Request for Additional Information

I refer to MOD 2: Extension of trial period trading hours and increased patron capacity (SSD-7683-Mod-2). After careful consideration, the Department is requesting that you provide additional information.

Ground Floor Seating Arrangement – Tenancy 5 of the Overseas Passenger Terminal

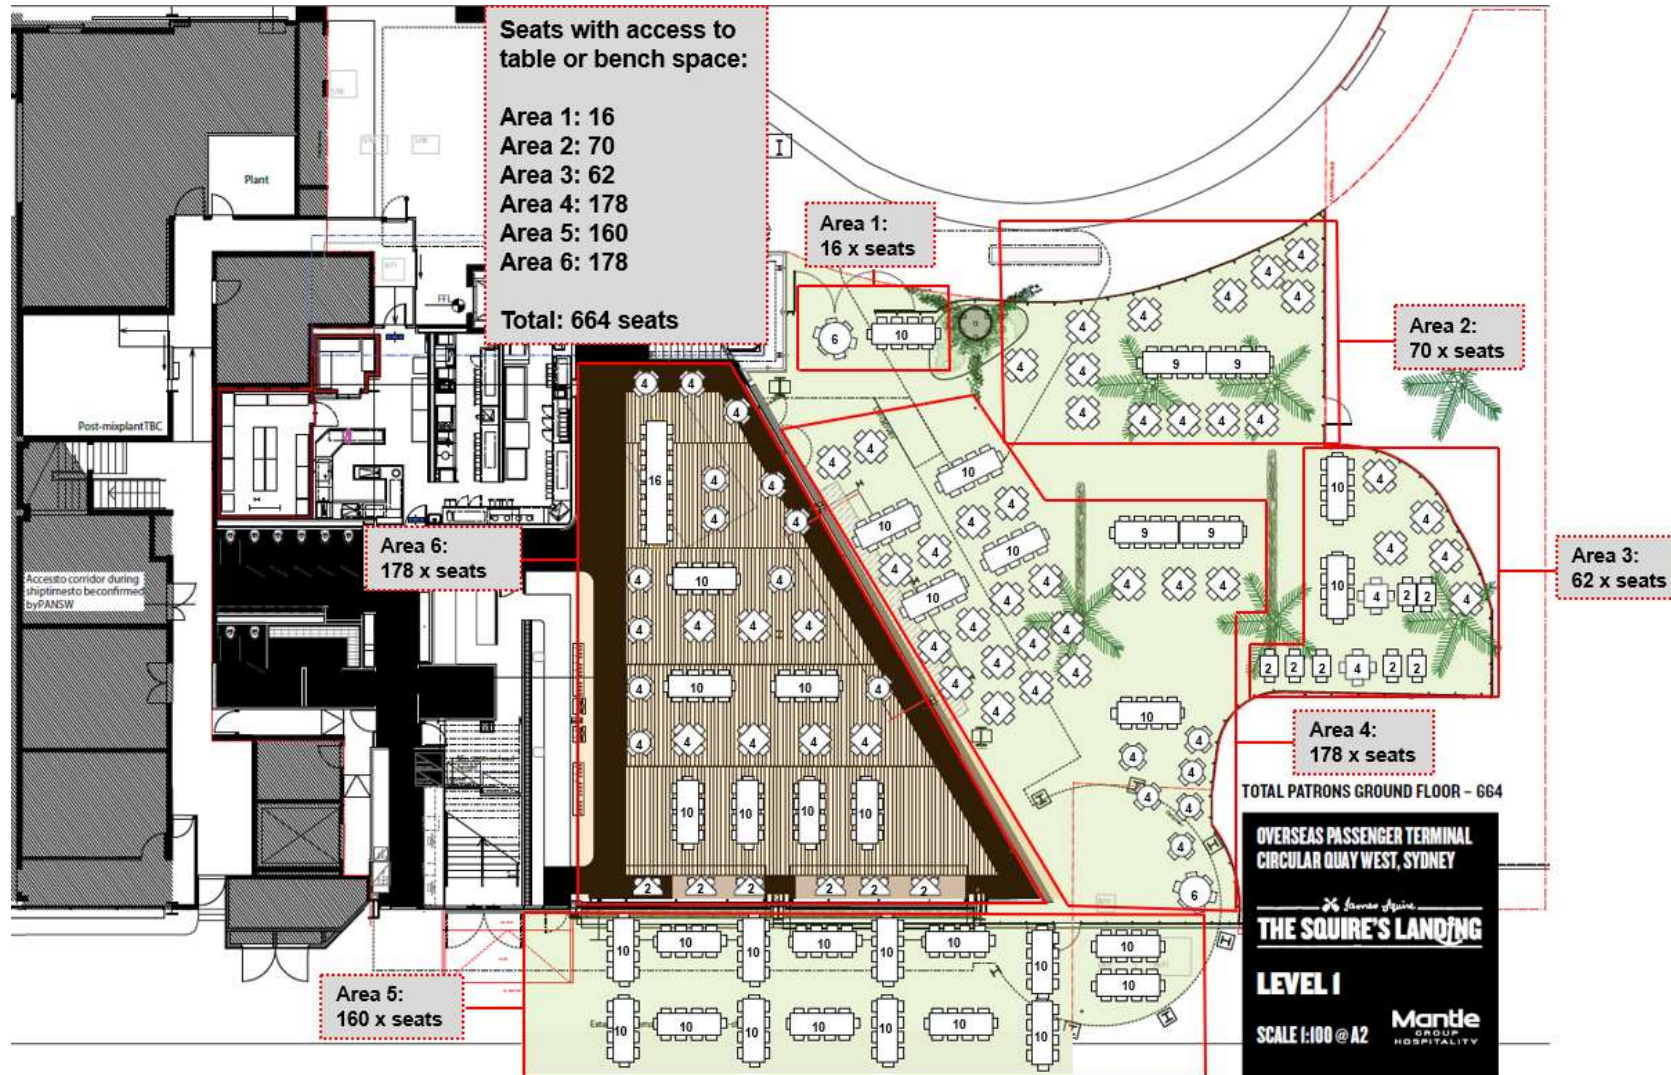
Demonstrate the Venue Floor Plan, in the Plan of Management, allocates a comfortable dining position for the 1000 patrons proposed under SSD 7682 MOD 2. As per Condition F4(iii), this must include a seat and access to table/bench space.
